Application No: EP/68/21/HH
Site Address: Merrydown Kingston Lane East Preston BN16 1RP
Description of works: Erection of timber framed detached garage with ancillary accommodation on first floor, installation of electric gated entrance, erection of new brick garden walls and extension to existing driveway and hardstanding.

OWQC38882

As the property is within the Elm Avenue, Golden Avenue (part), Kingston Lane (part) North Lane (part) East Preston Area of Special Character, the committee agreed to object to this Application on the following grounds.

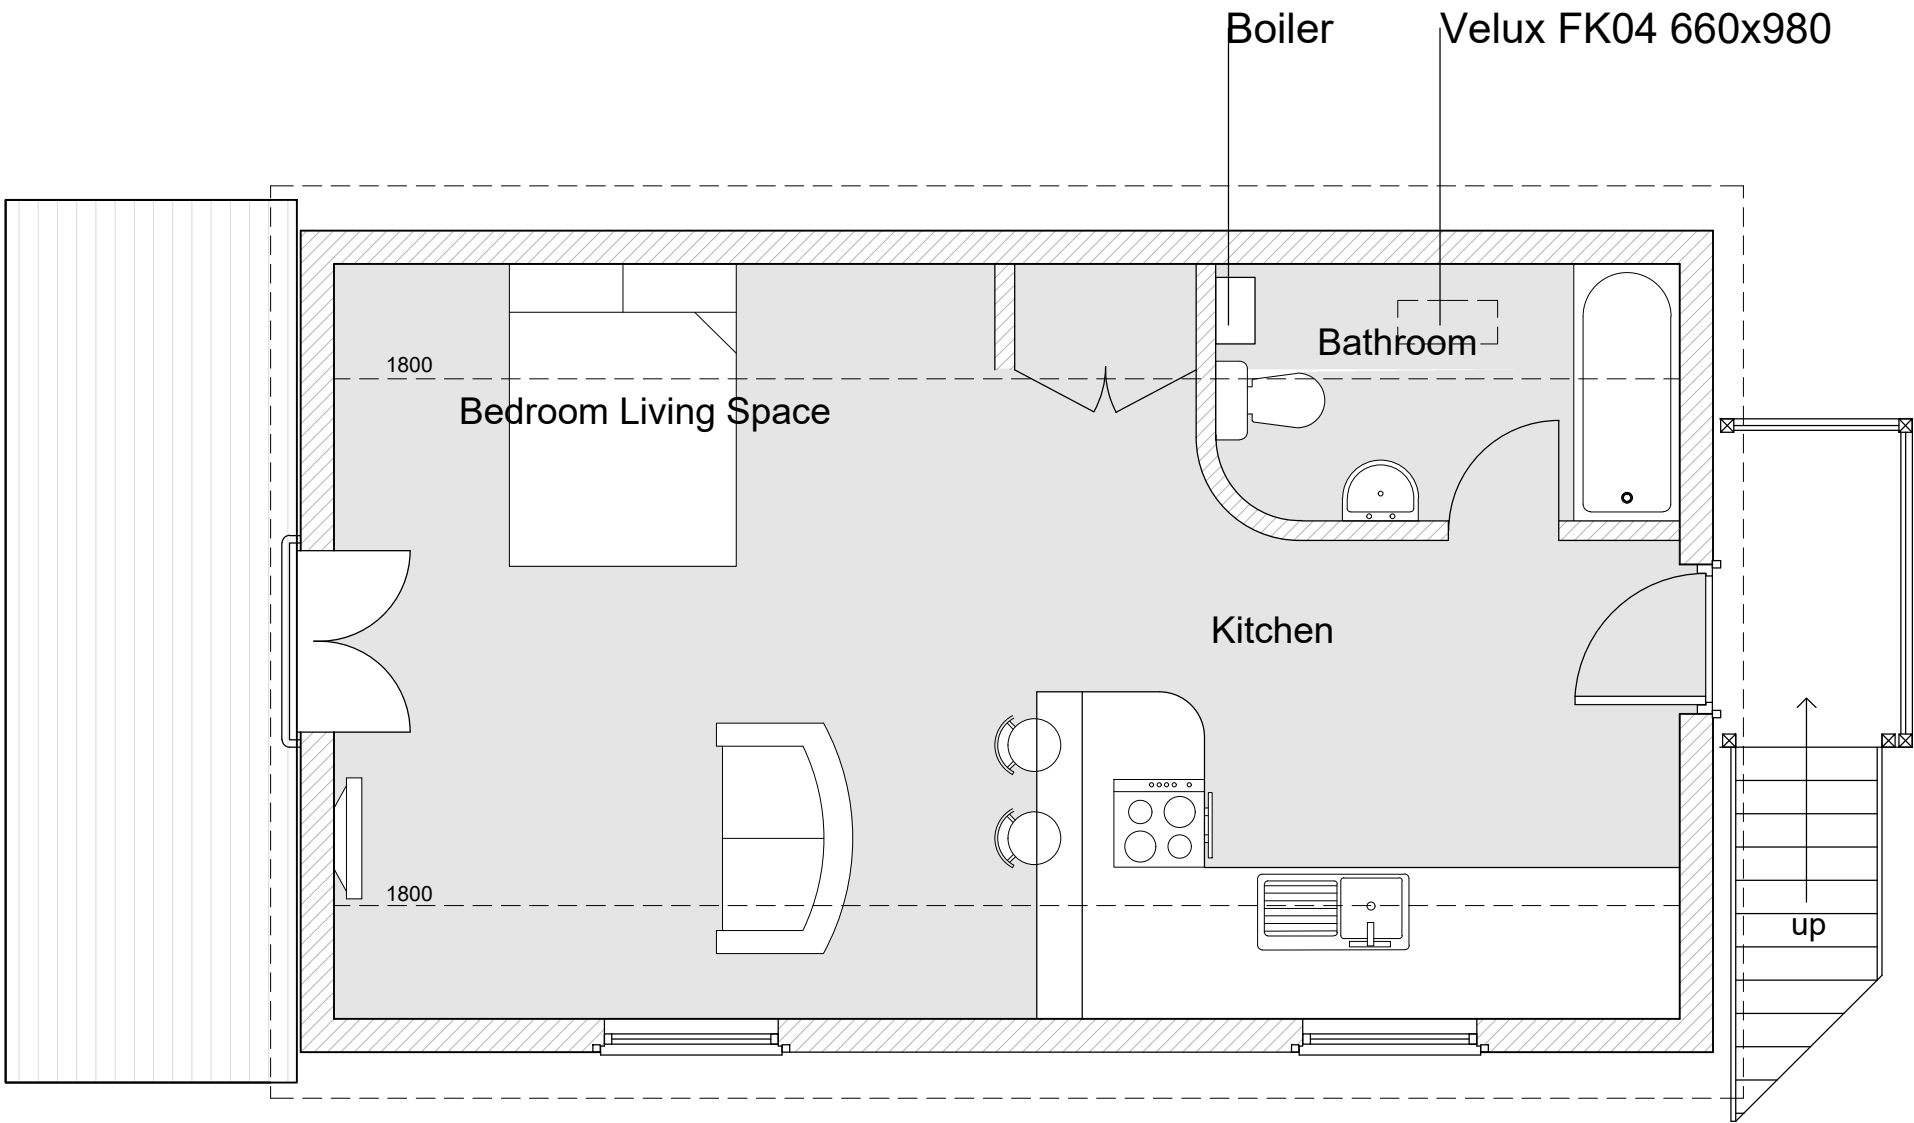
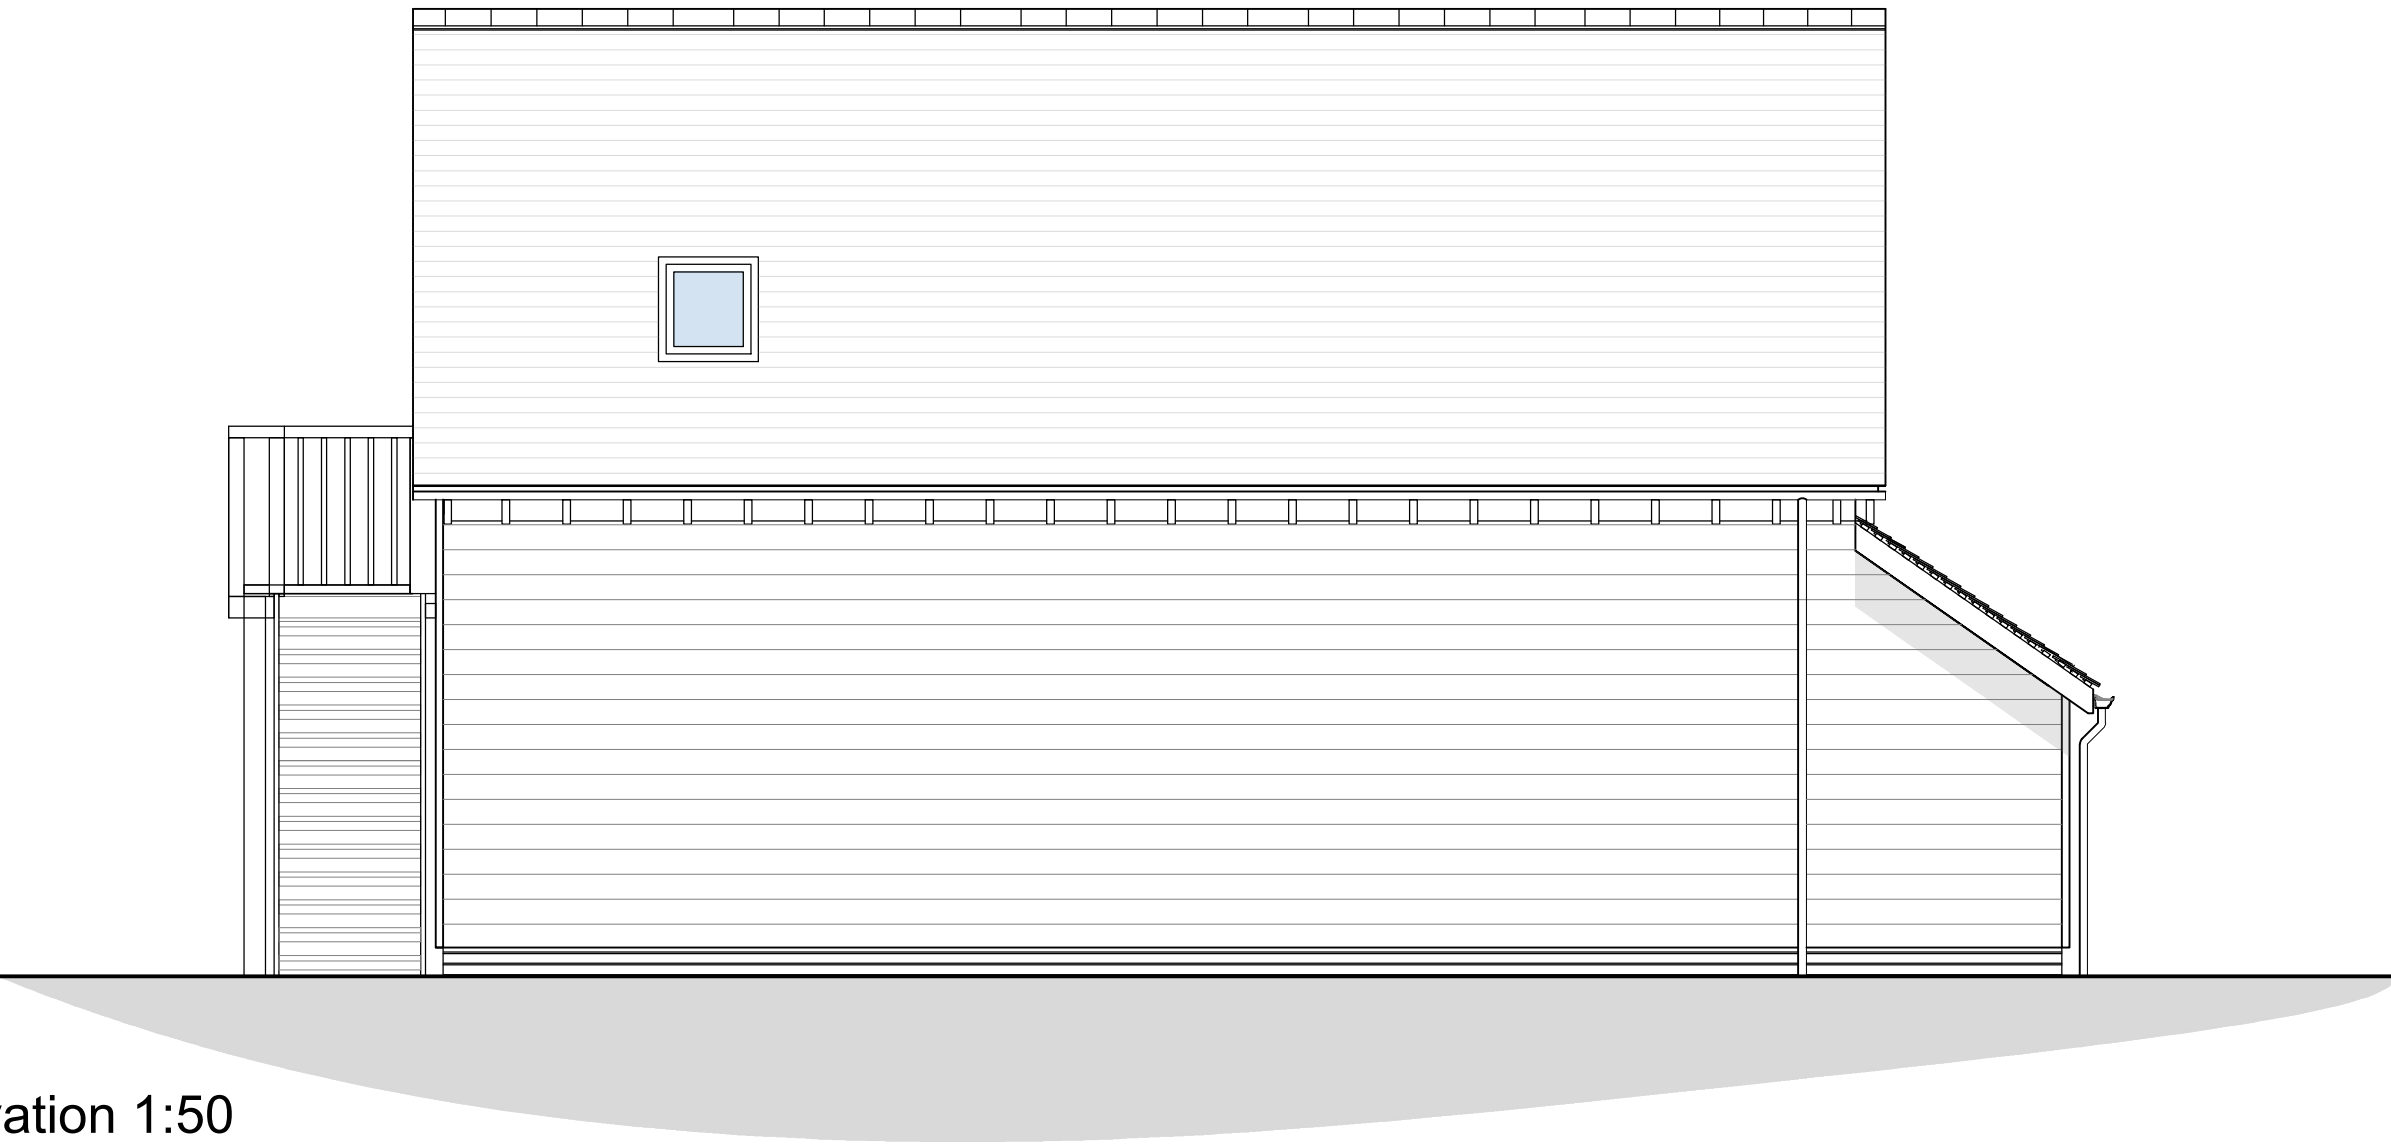
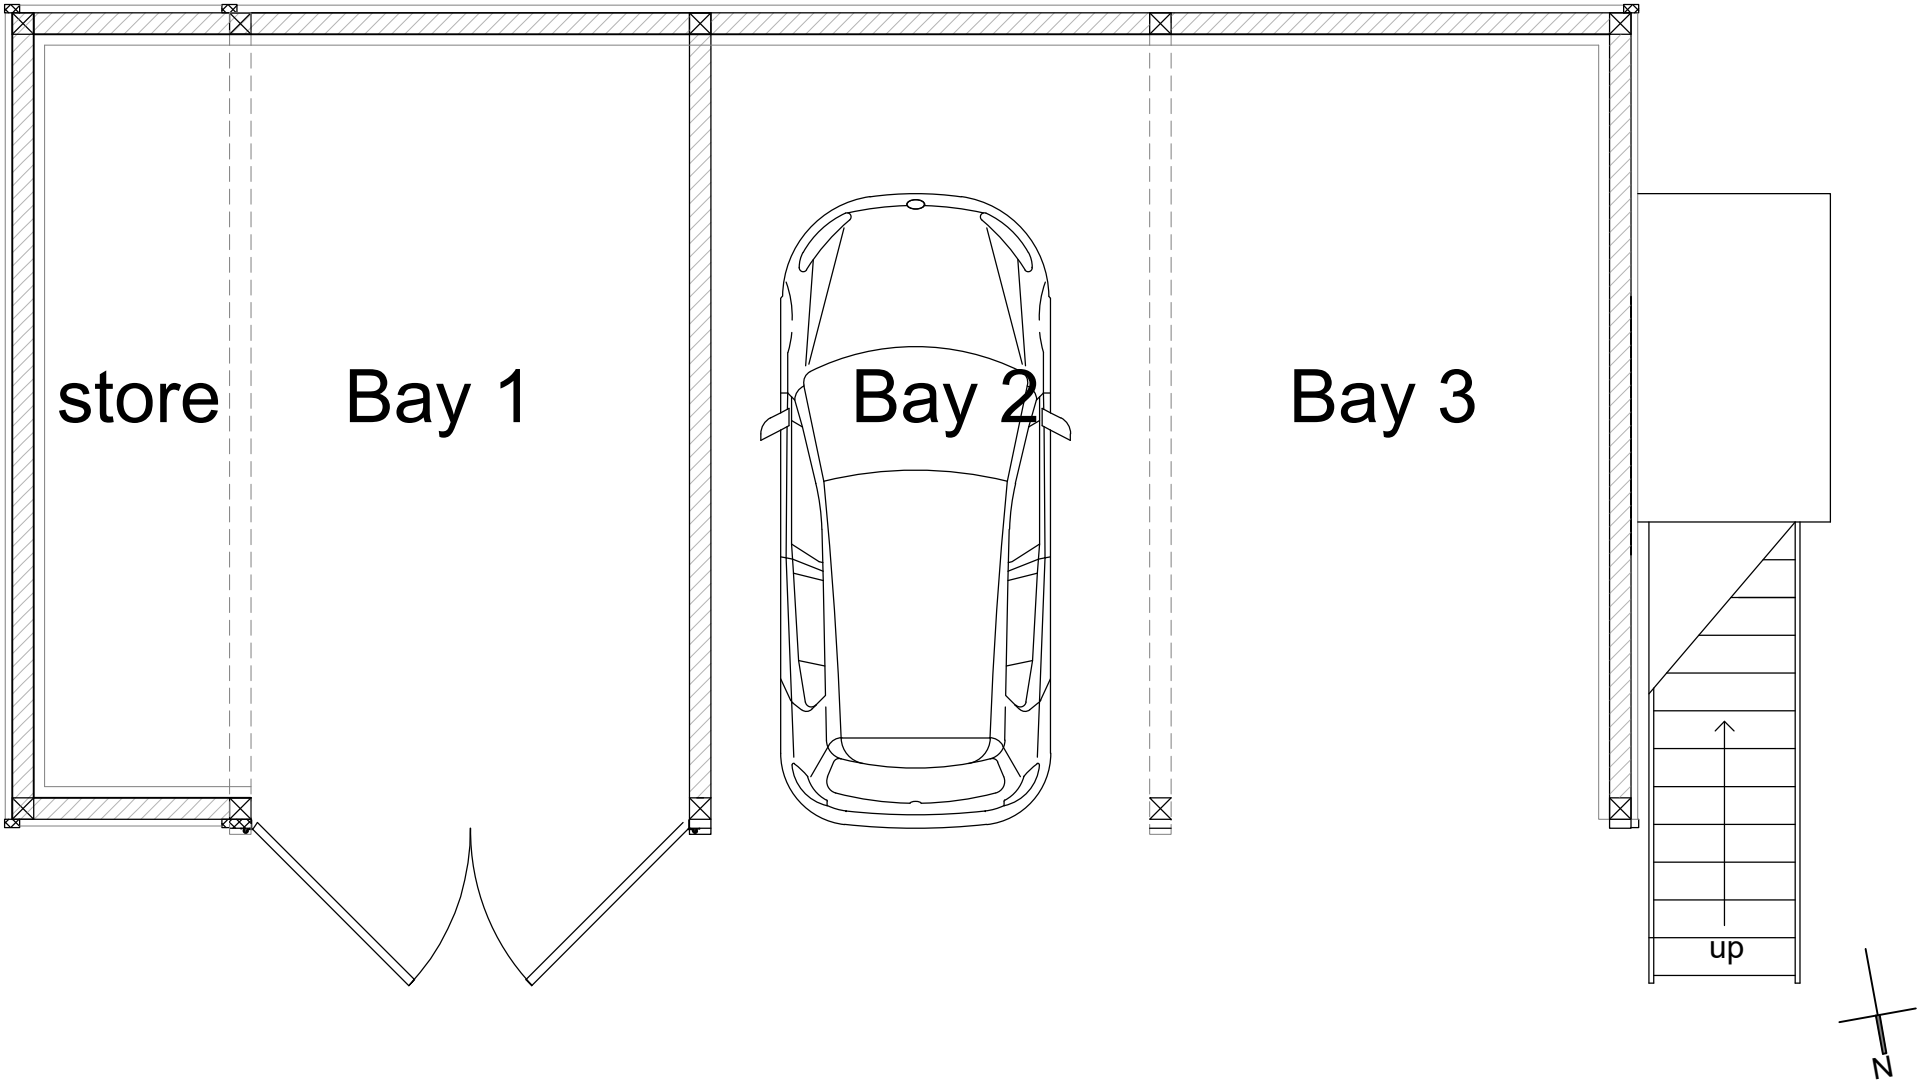
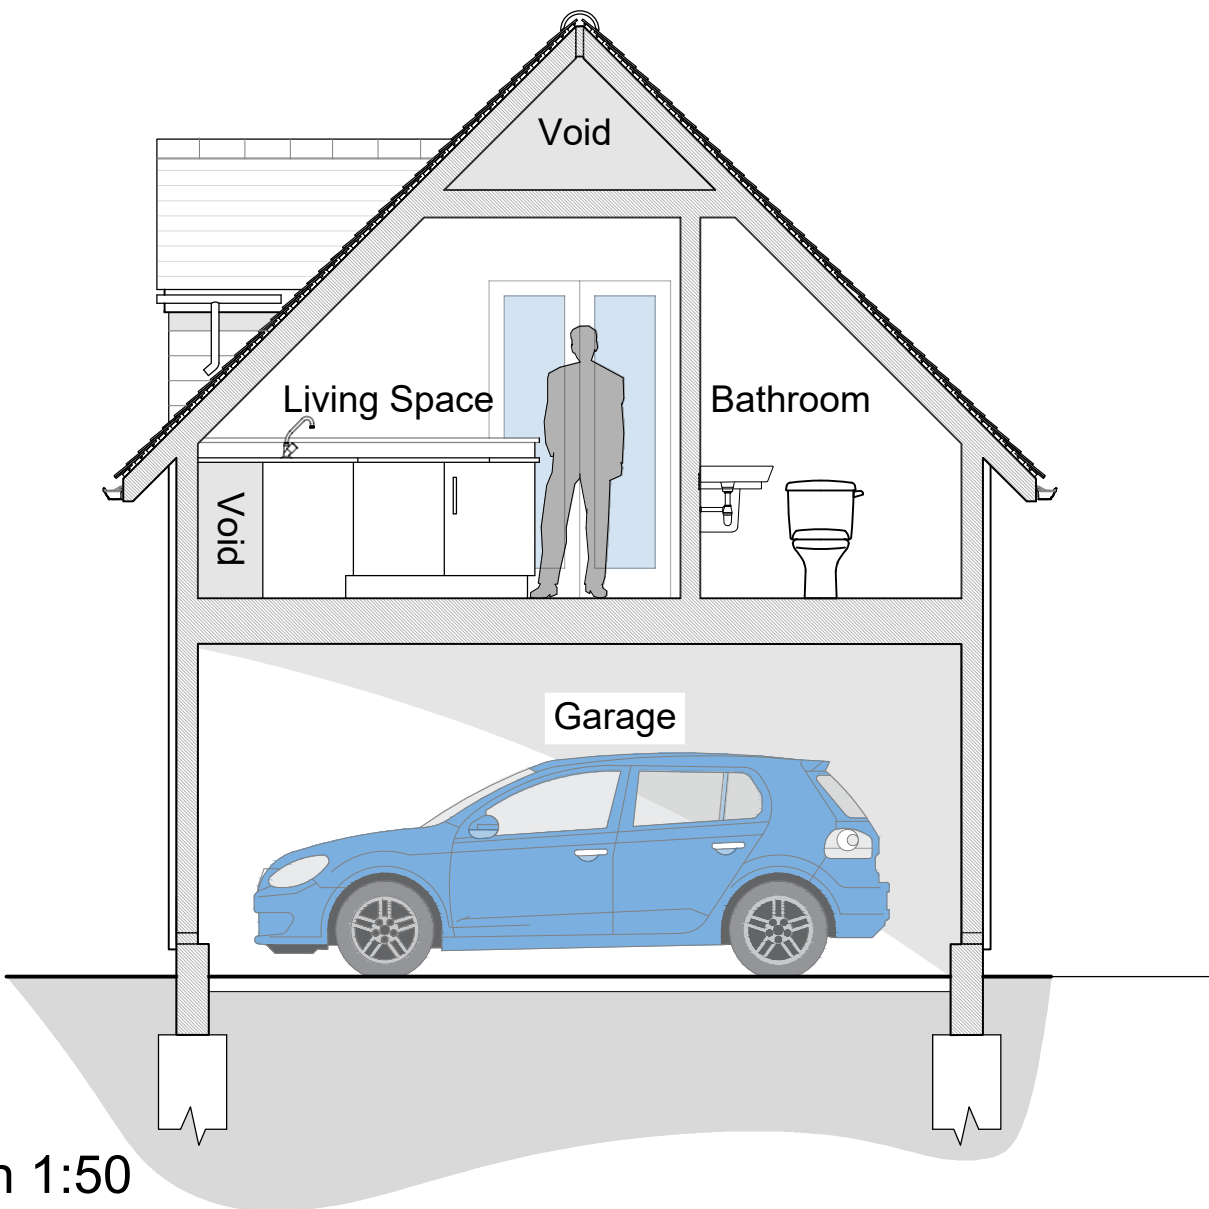
1. The proposed garage is deemed to be too close to the front boundary and would be better sited further back, at least to be in line with the eastern elevation of Oakcroft to the south. This would address the comment in the description of the Area of Special Character, There is a regular building line .

2. The proposed gate is very solid and not in keeping with the semi-rural setting of this property.
3. The proposed use of slate on the garage roof is out of keeping with the earth-tones palette of materials on nearby buildings and possibly also contrary to the semi-rural setting of this property.
